**Re: Design Submission for Housing Development at Crown Square Development, Monivea Road, Galway (the “Development”) (the “Design Submission”) / 953699652.**

- 183-106-051-PL1 Proposed Ground Floor Drainage Layout – Phase 2
- 183-106-053-PL1 Basement Floor Drainage – Phase 2
- 183-106-054-PL1 Watermain Layout – Phase 2
- 183-106-057-PL0 Drainage Longitudinal Sections – Sheet 3 of 6
- 183-106-058-PL0 Drainage Longitudinal Sections – Sheet 4 of 6
- 183-106-060-PL0 Drainage Longitudinal Sections – Sheet 6 of 6

Drawing file: Engineering / 183-106-060 PL0.pdf

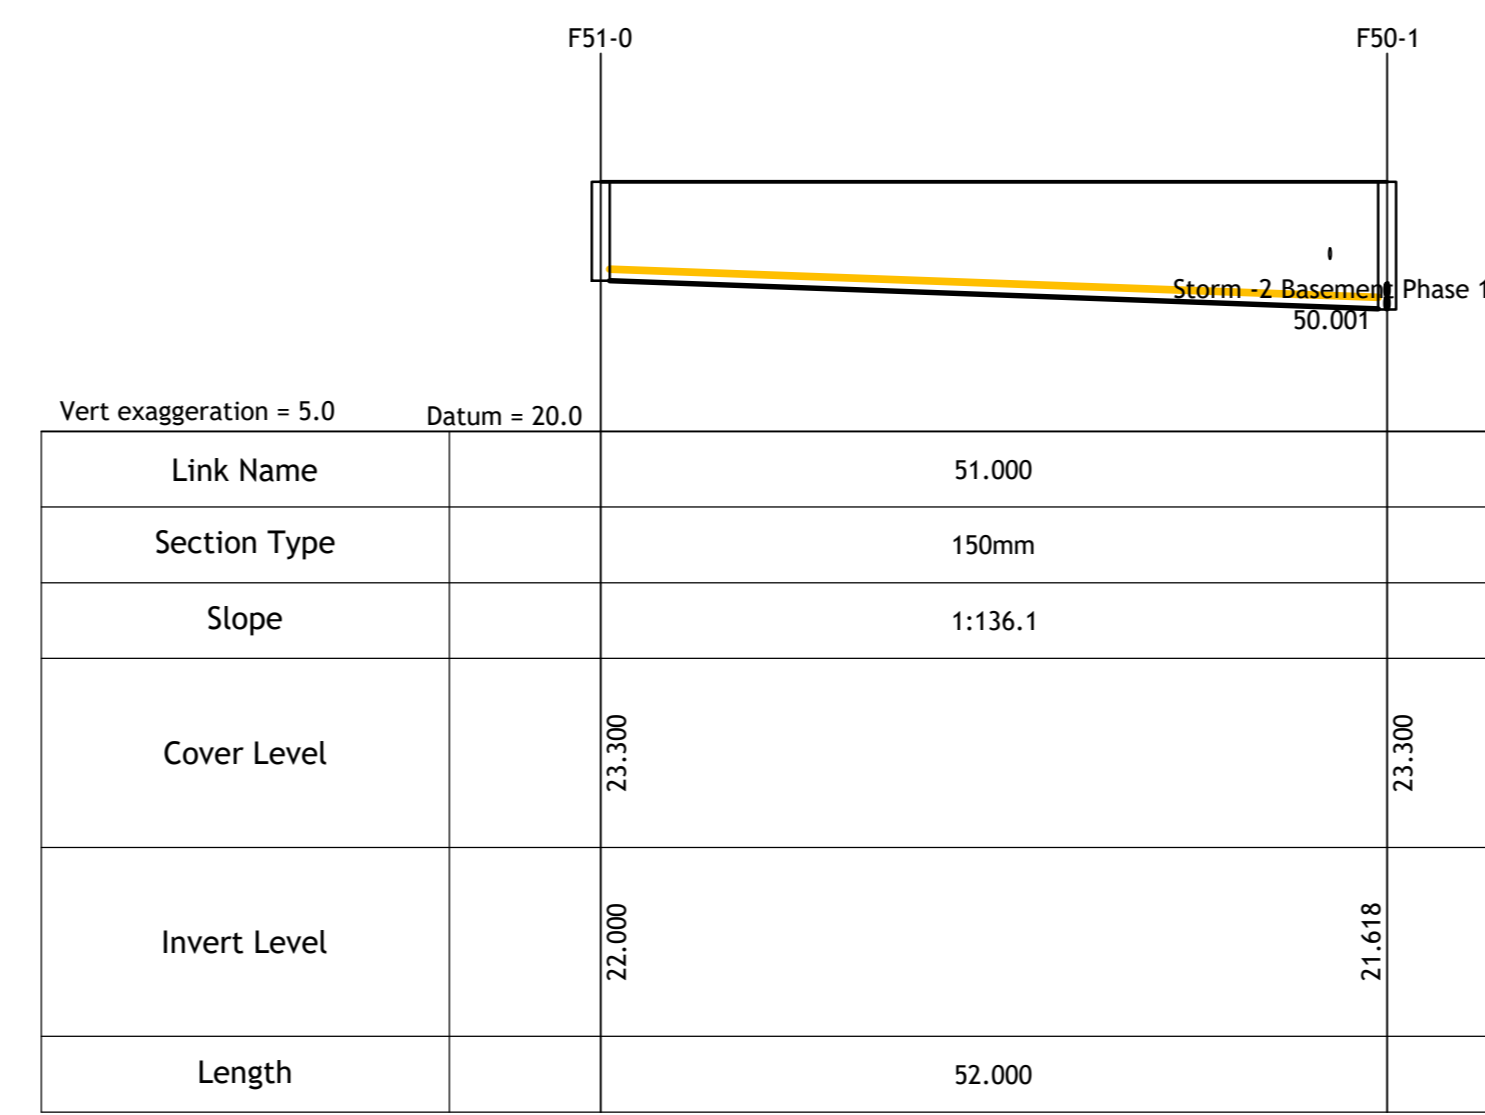
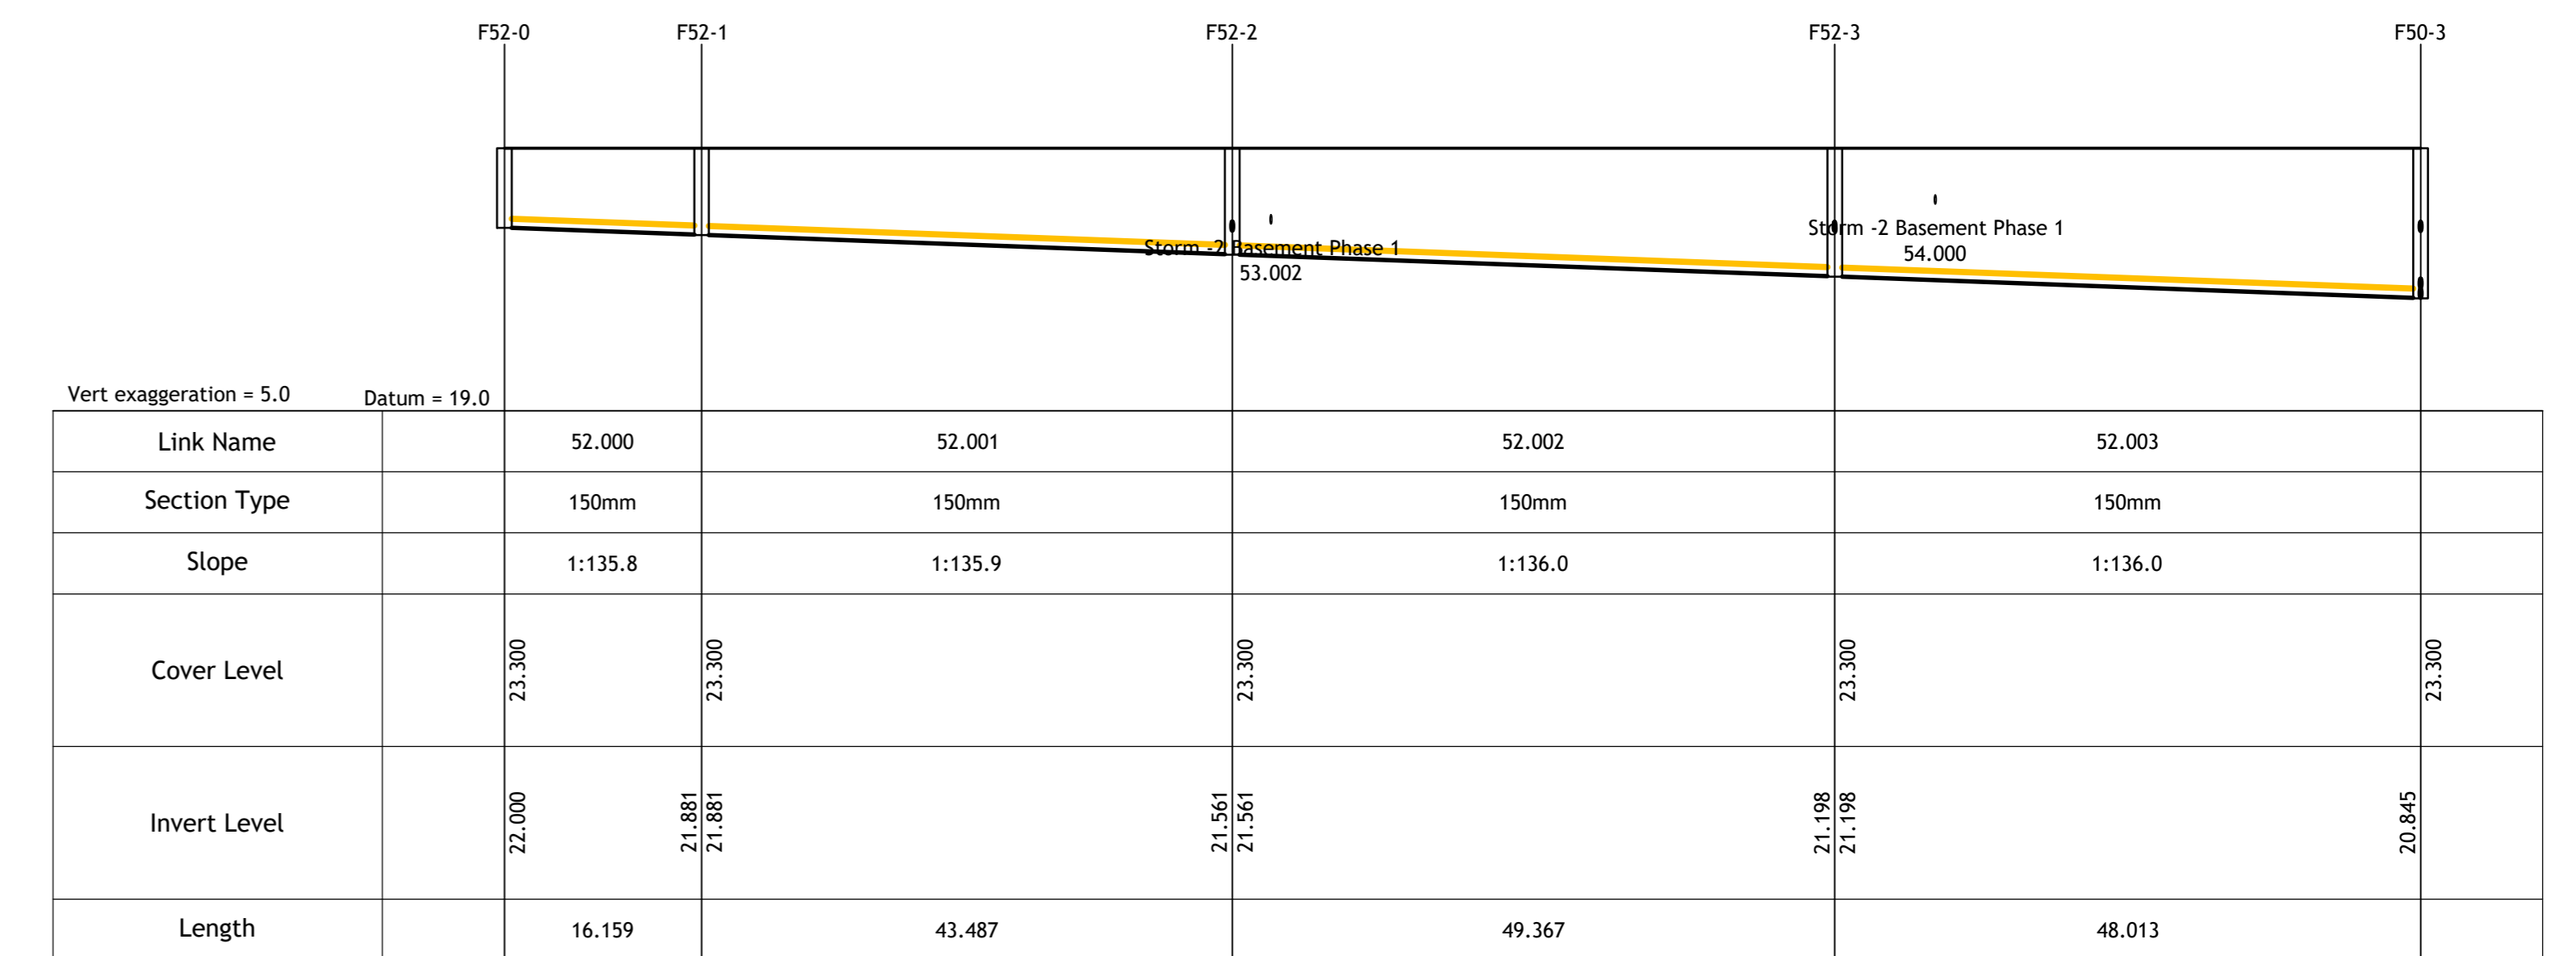
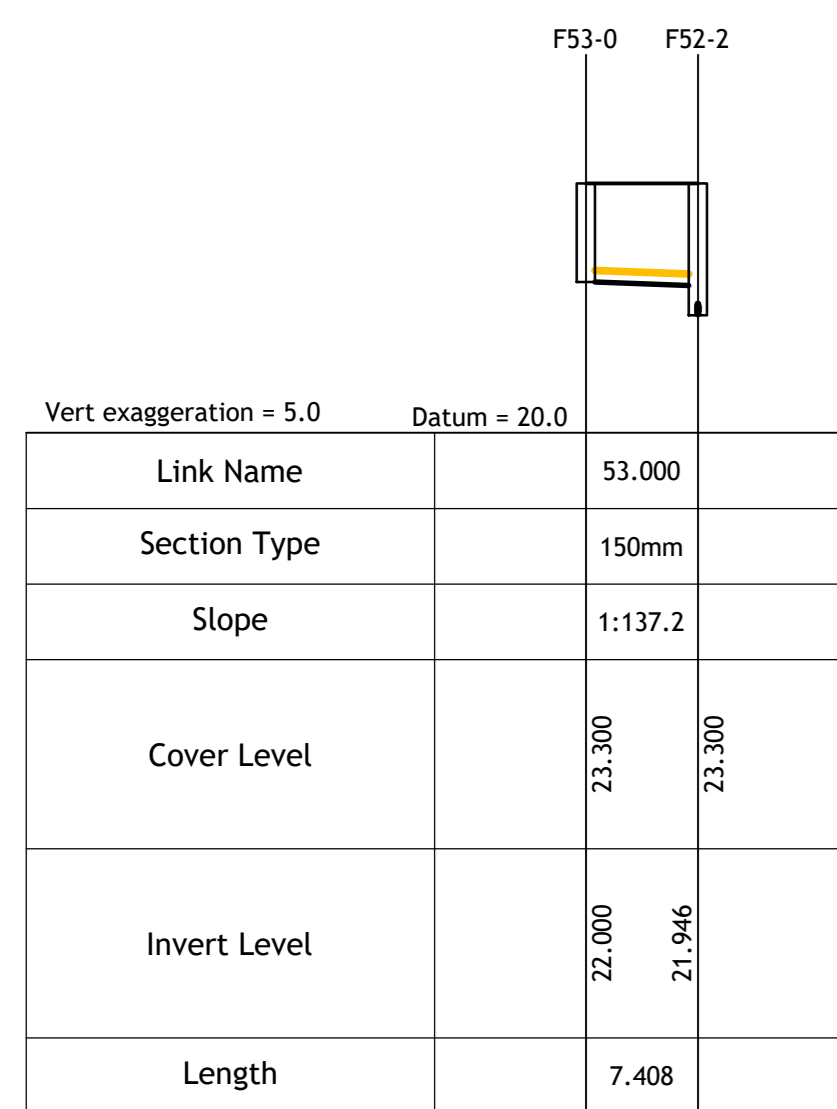
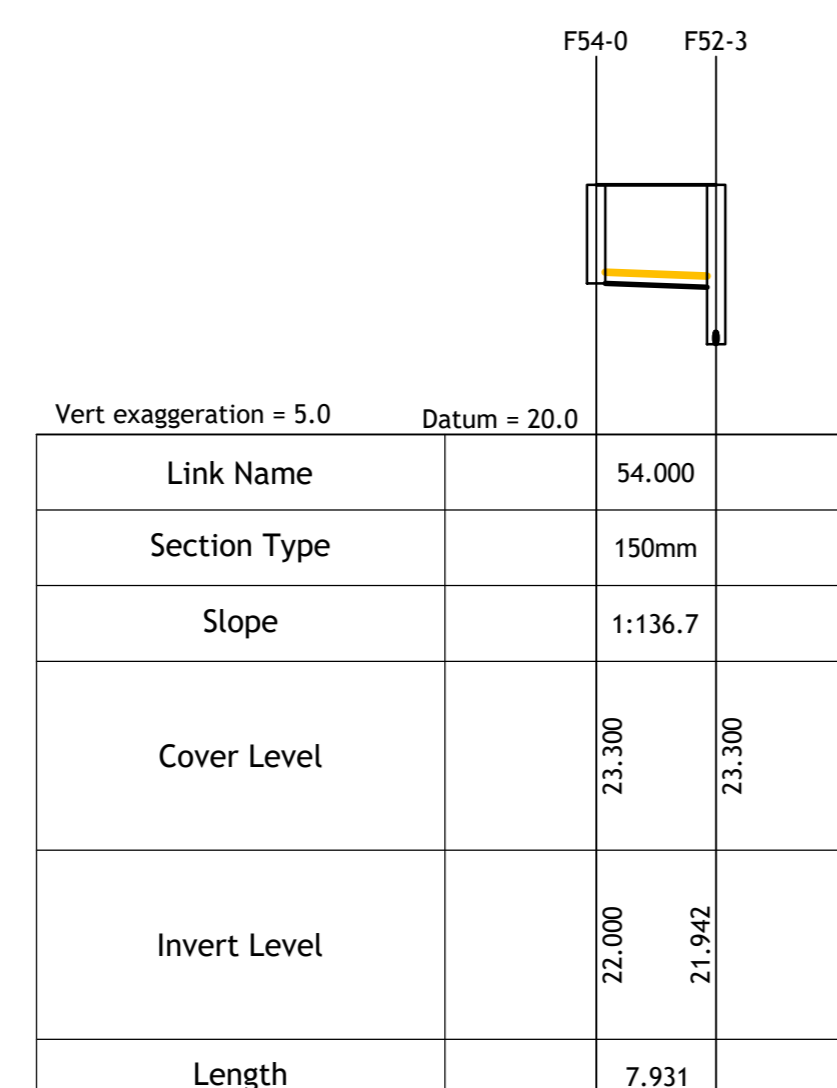
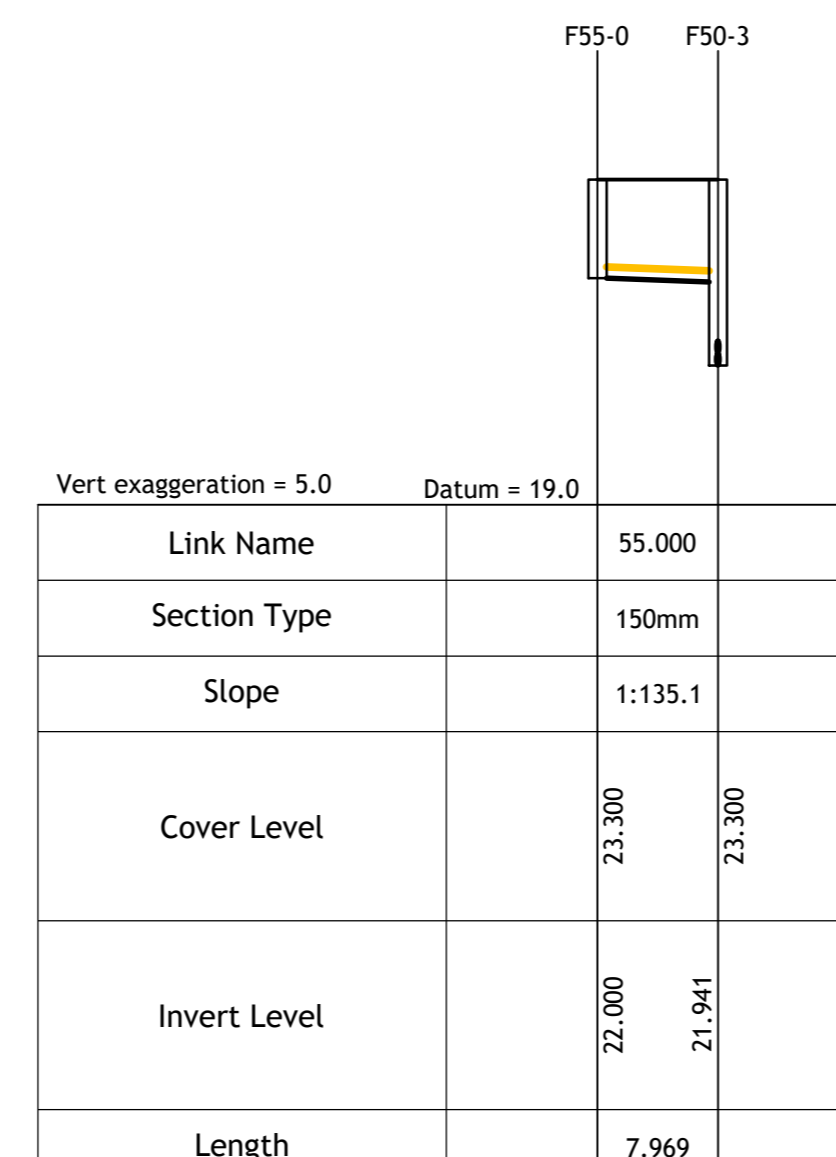
**\* Statement of Design Acceptance conditional that minimum cover to FC20-10 is increased to 500mm as per section 3.9.1 of the Wastewater Code of Practice**
